Application for a Non-Material Amendment Following a Grant of Planning Permission

Proposed side extension at first floor level Proposed side infill extension to rear of existing garage and proposed glass extension to rear elevation at ground floor level.

PP-12134579

PROJECT	1 Coniston Close	
	London	
DRAWING TITLE	PLANNING	
	PROPOSED ELEVATIONS	
DATE	FEB 24	SCALE @ A1
DRAWN	MC	CHECK SS
STATUS		
JOB NUMBER		
DRAWING NUMBER	DR-A-02	REV C

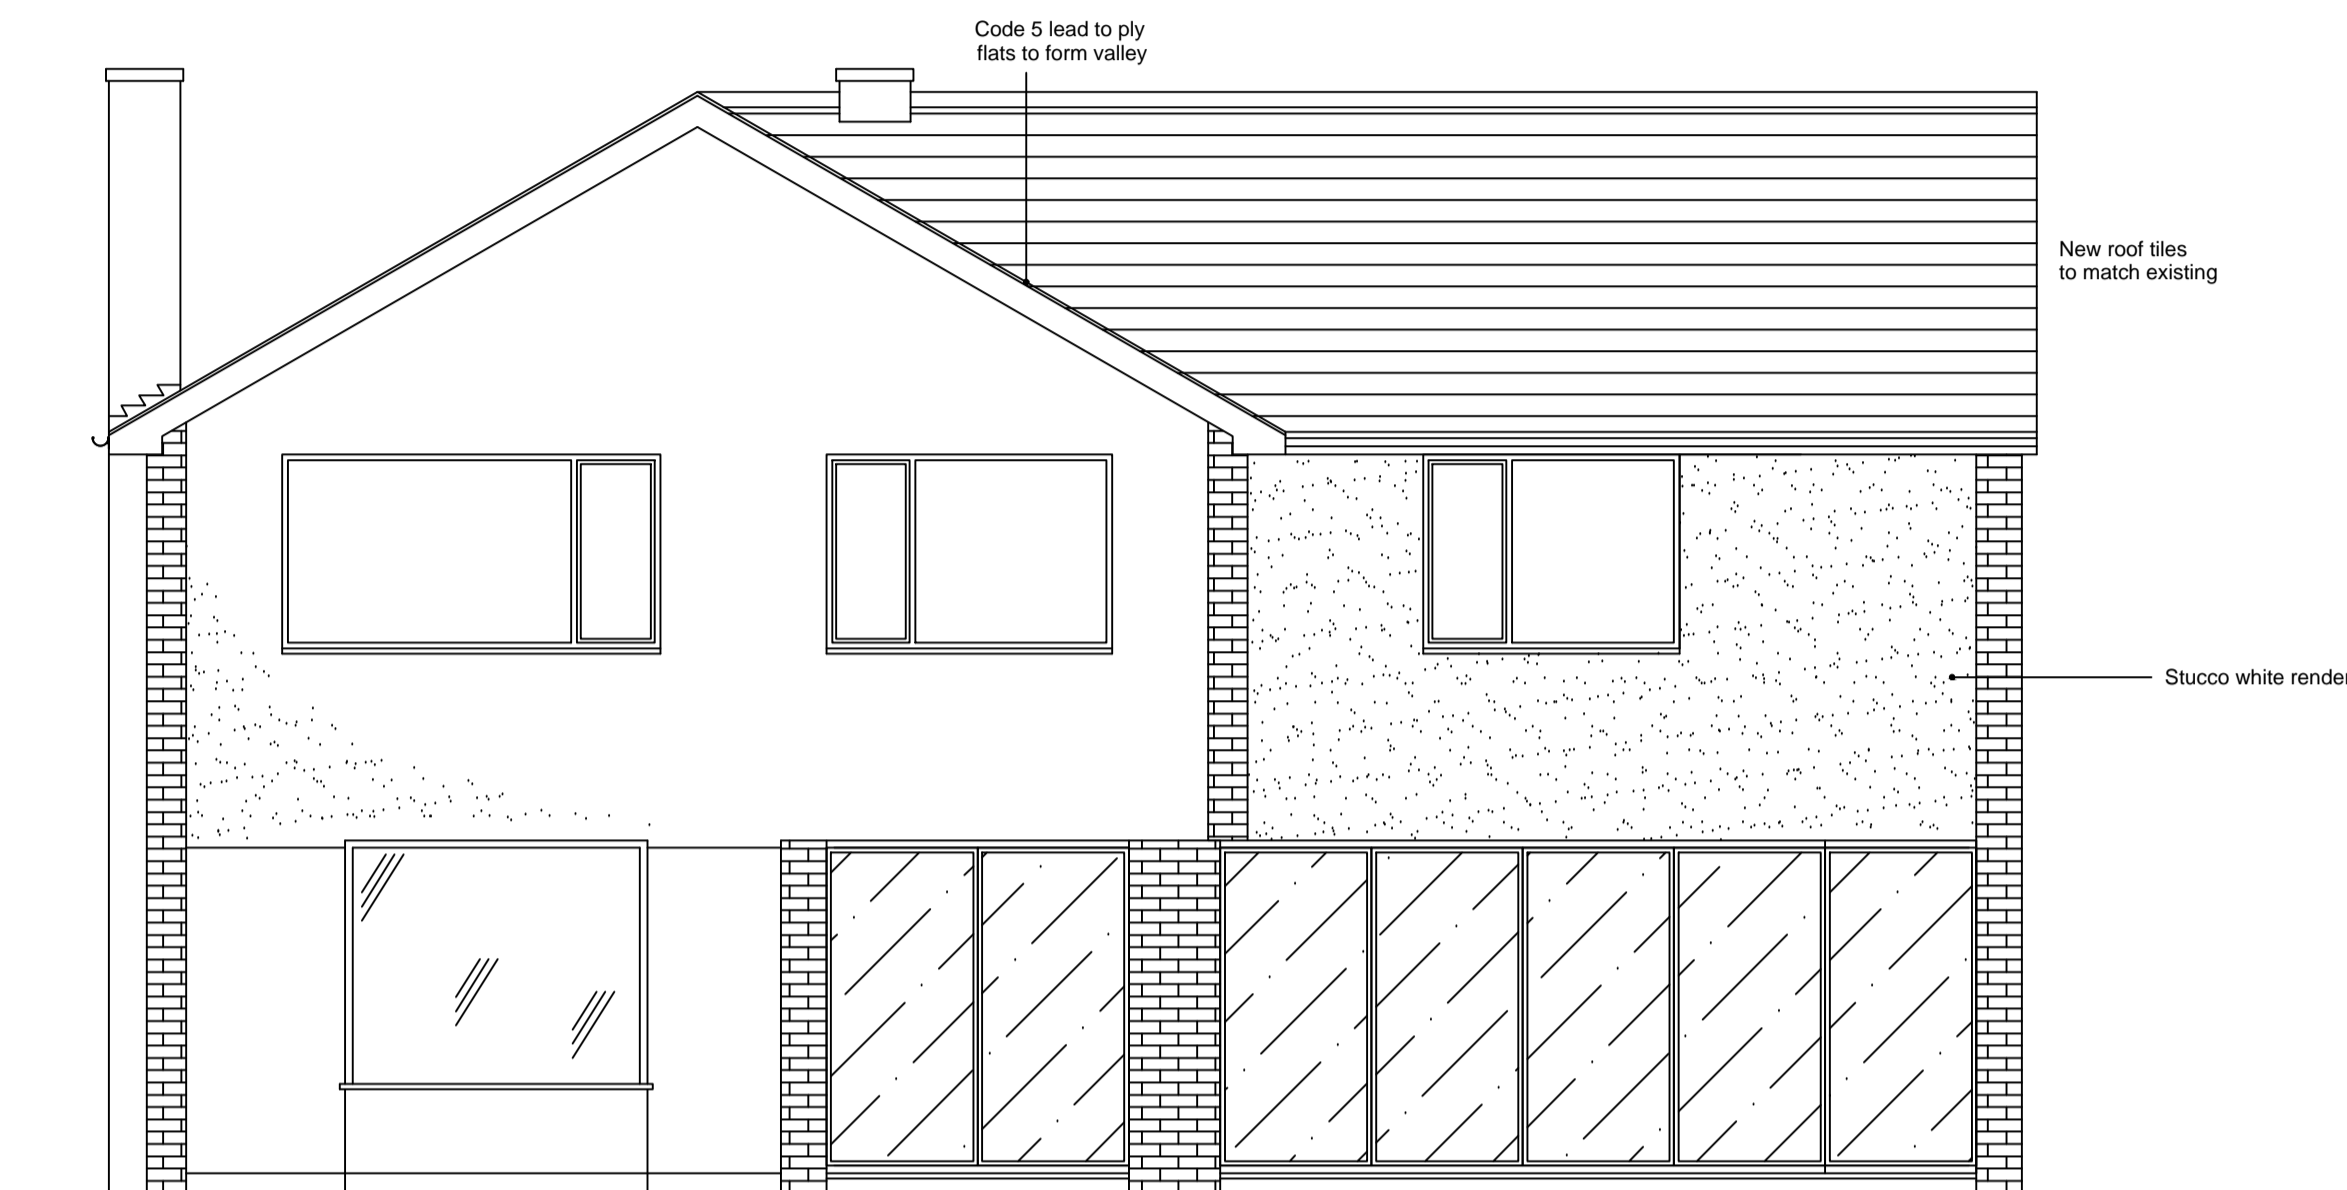
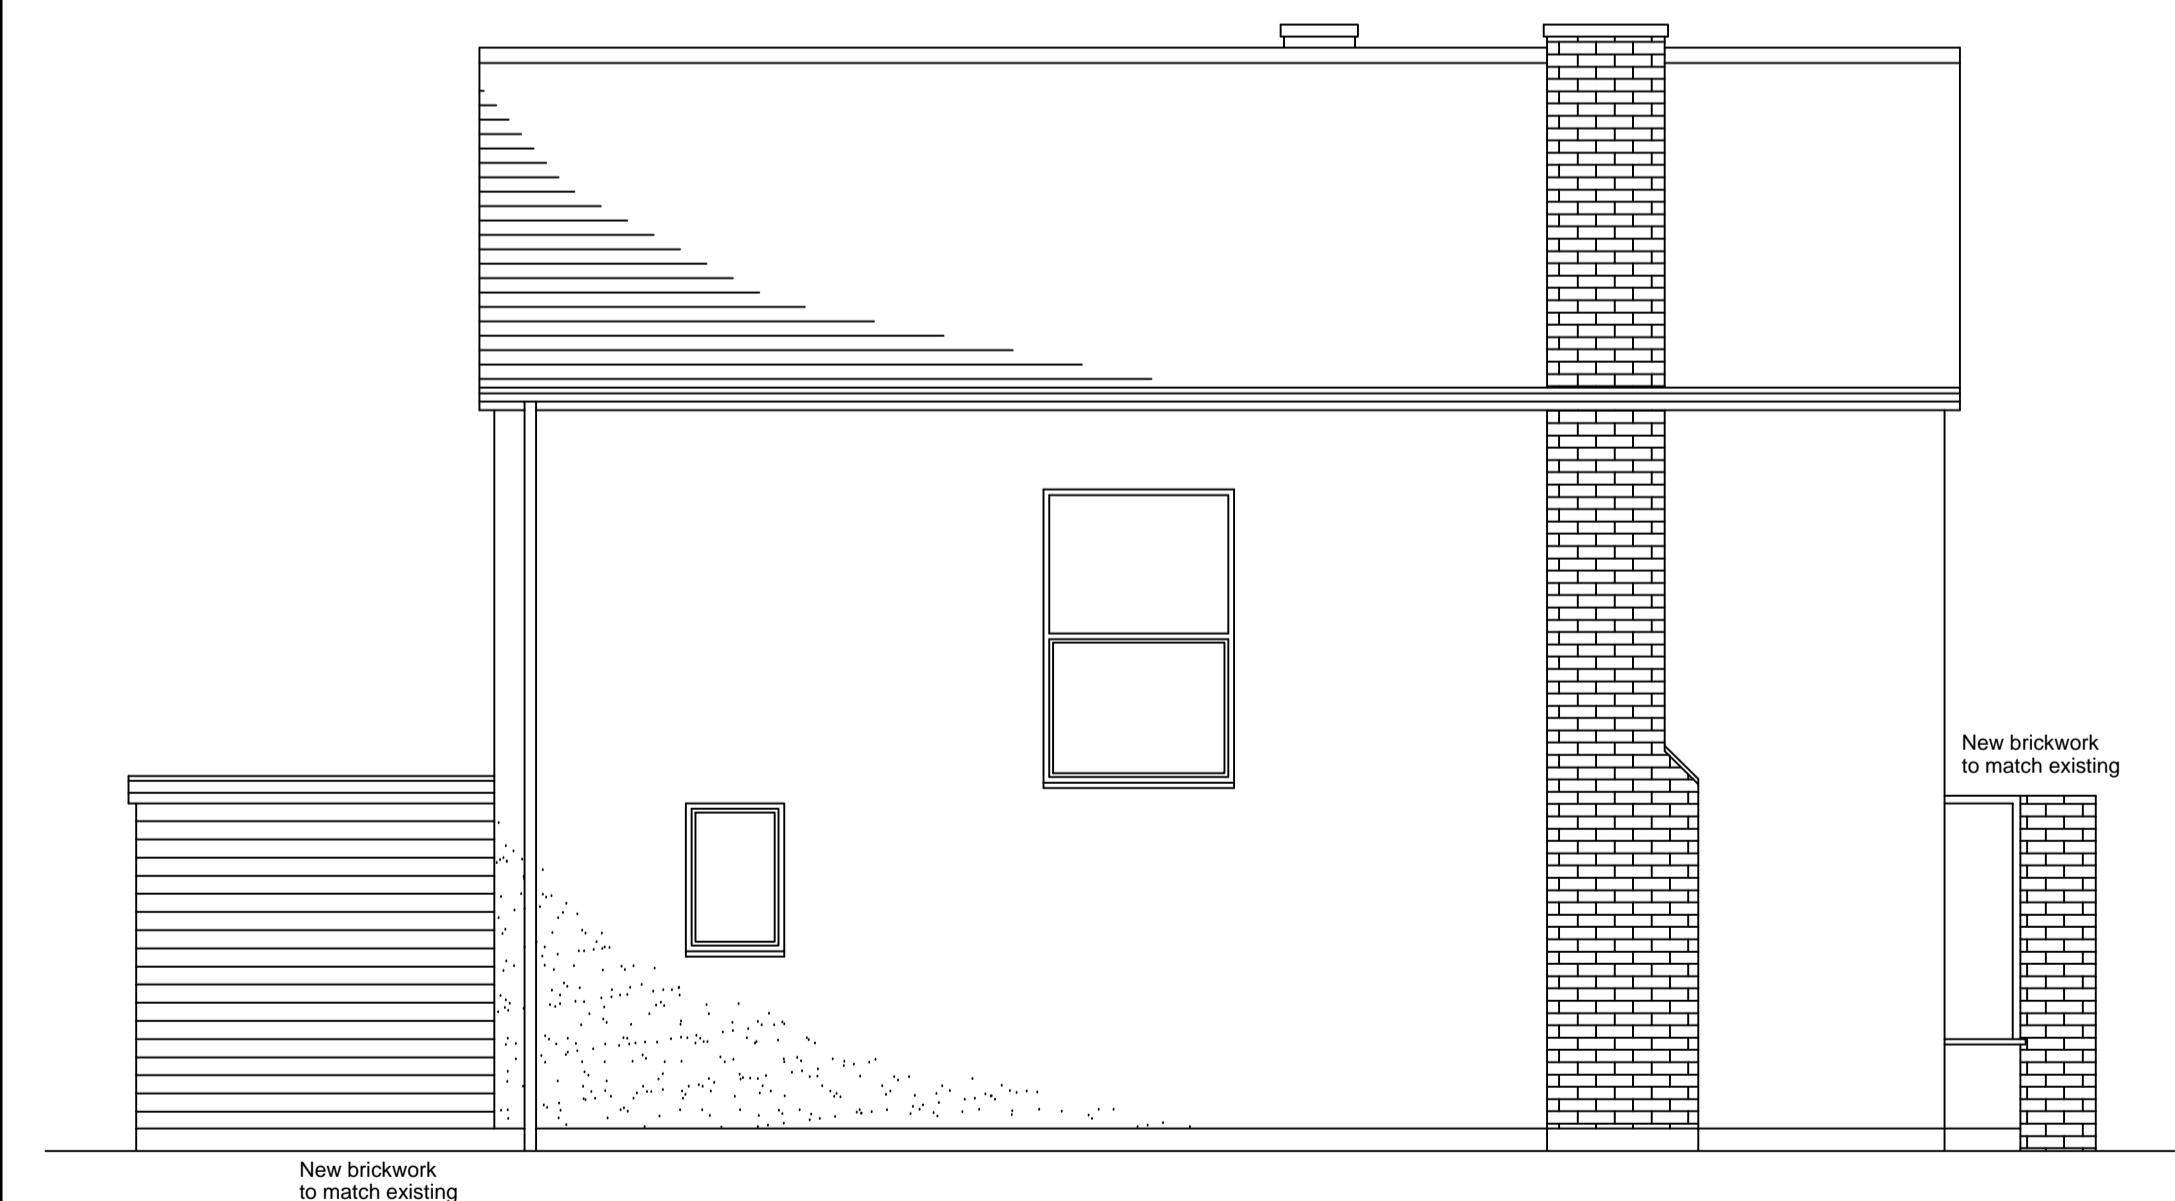
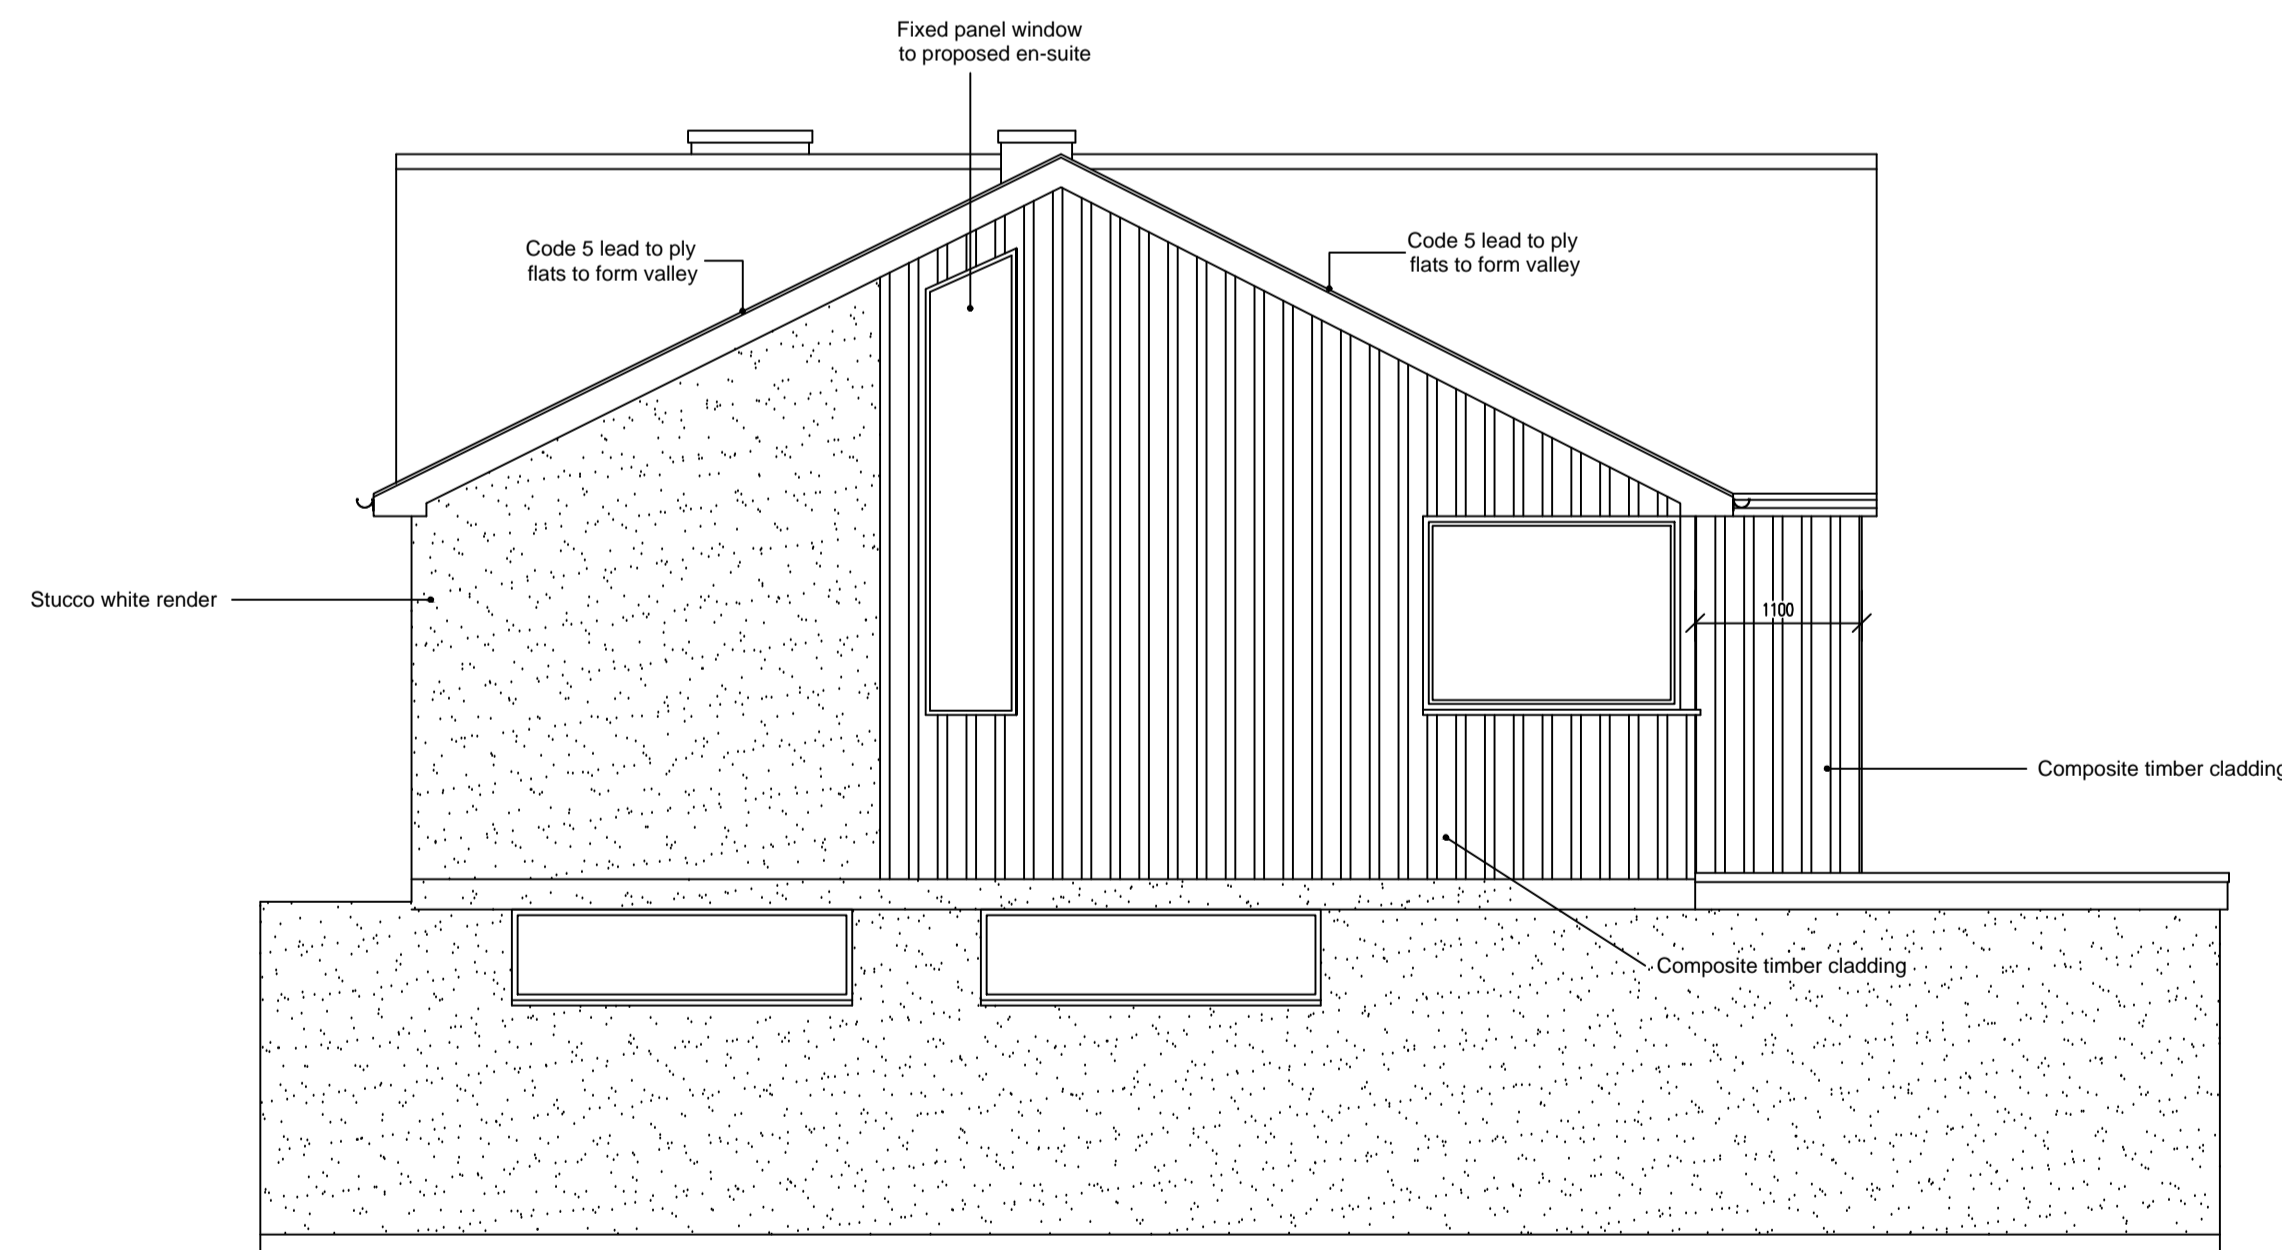
Proposed white stucco render at ground floor level to front and side elevation.
Proposed white stucco render to rear elevation and side elevation.
Proposed timber cladding at first floor level front elevation and side elevation.
